Office of Water

24 September 2010

**Subject: Riverina Oils and Bio Energy, Integrated Oilseed Processing Facility (MP07_0146 MOD1)
Environmental Assessment**

Figure 1: Graphical Representation of Annual Rainfall 1999 – 2006

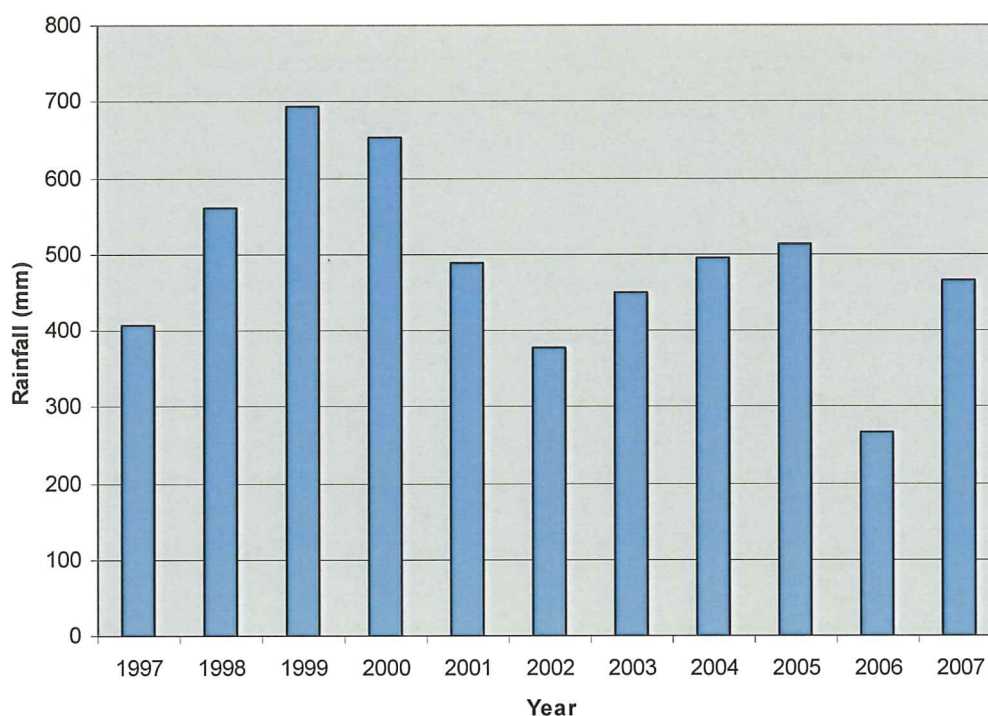
- 1) The hydrogeological technical report submitted is dated March 2008 and has not been updated to account for the new wastewater storage pond or changes in climatic conditions during 2008 to 2010. The use of average annual groundwater levels and quality data is not adequate to determine seasonal variability of levels and quality within the shallow perched and deeper aquifer; to assess connectivity between these two aquifers; linkage to rainfall; and to establish trigger level criteria. There are a number of NOW monitoring bores within the area which could have been accessed for comprehensive groundwater contours and flow directions to be determined.

- c) daily rainfall presented to enable comparison with groundwater levels,
 - d) graphs showing changes in water quality over the baseline period to show any seasonal and locality variations,

Figure 3: Groundwater bores

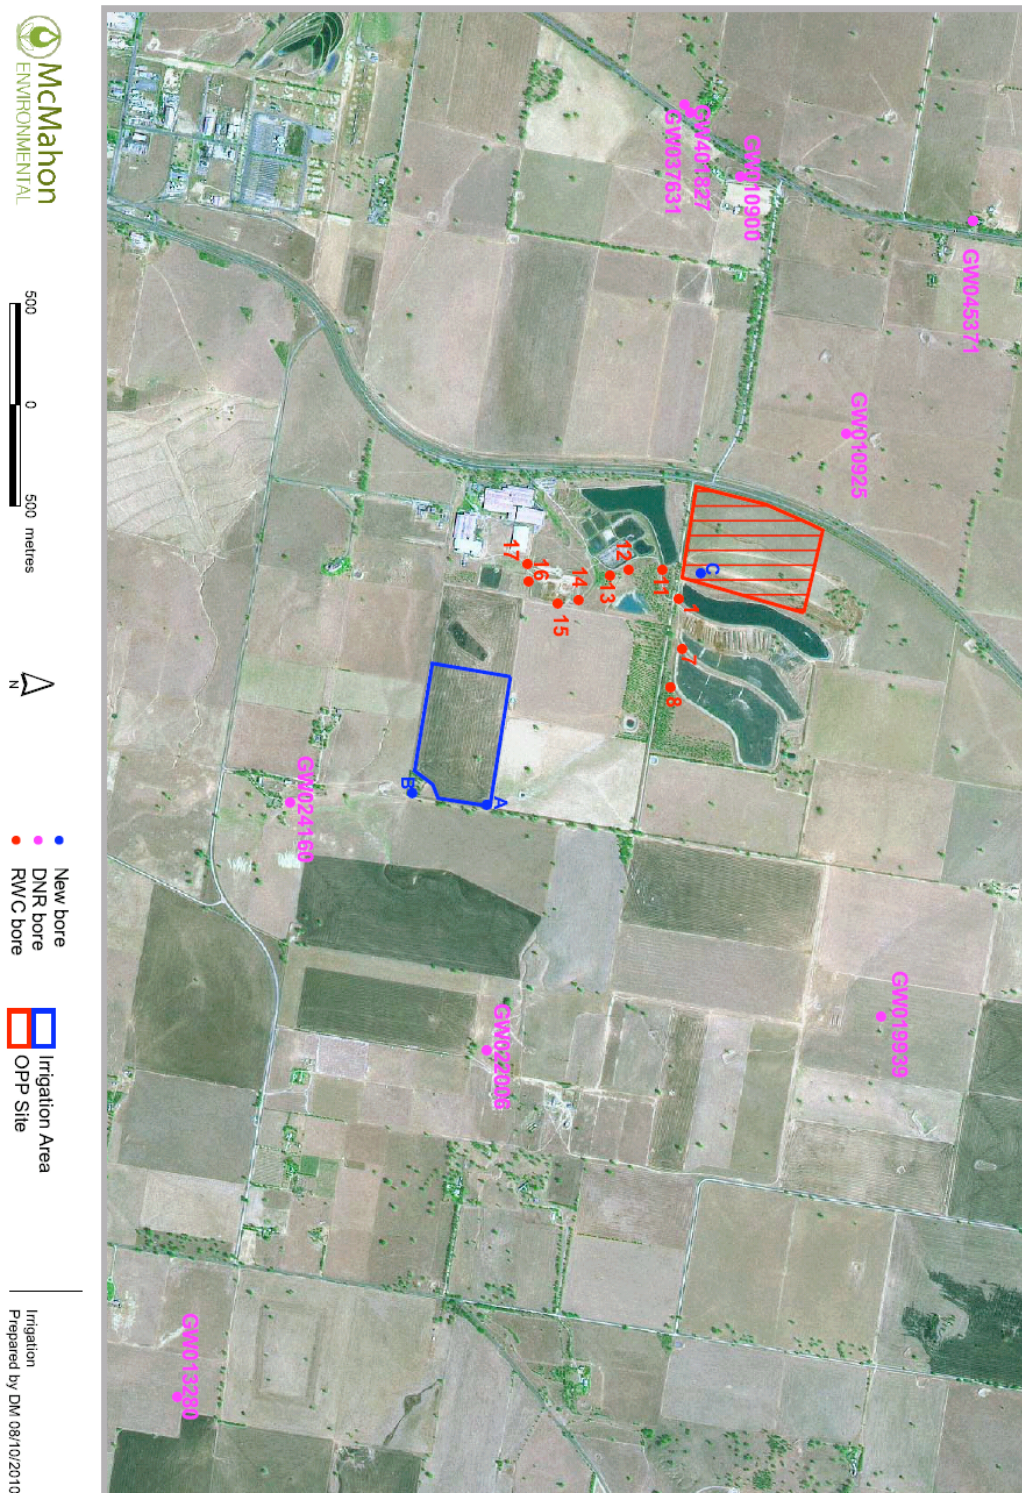
- 4) The monitoring proposed in the Groundwater Management Plan (GMP) for leakage from the wastewater dam on an annual basis is inadequate to detect for any impacts to the groundwater from any potential leakage from the dam.

- a) A map showing the proposed monitoring bores in relation to the wastewater dam including information on bore depths and screen levels,
 - b) updated hydrographs using raw data not average annual data to show seasonal variability and responses to rainfall to be presented as line graphs not bar graphs,

In addition the Groundwater Management Plan needs amending for the proposed monitoring of the wastewater storage pond for leakage detection. The proposed monitoring on an annual basis needs to be changed to monthly monitoring to ensure minimum impacts to the groundwater due to leakage are detected. Mitigation and contingency measures also need to be incorporated into the WMP for the potential of pond leakage.
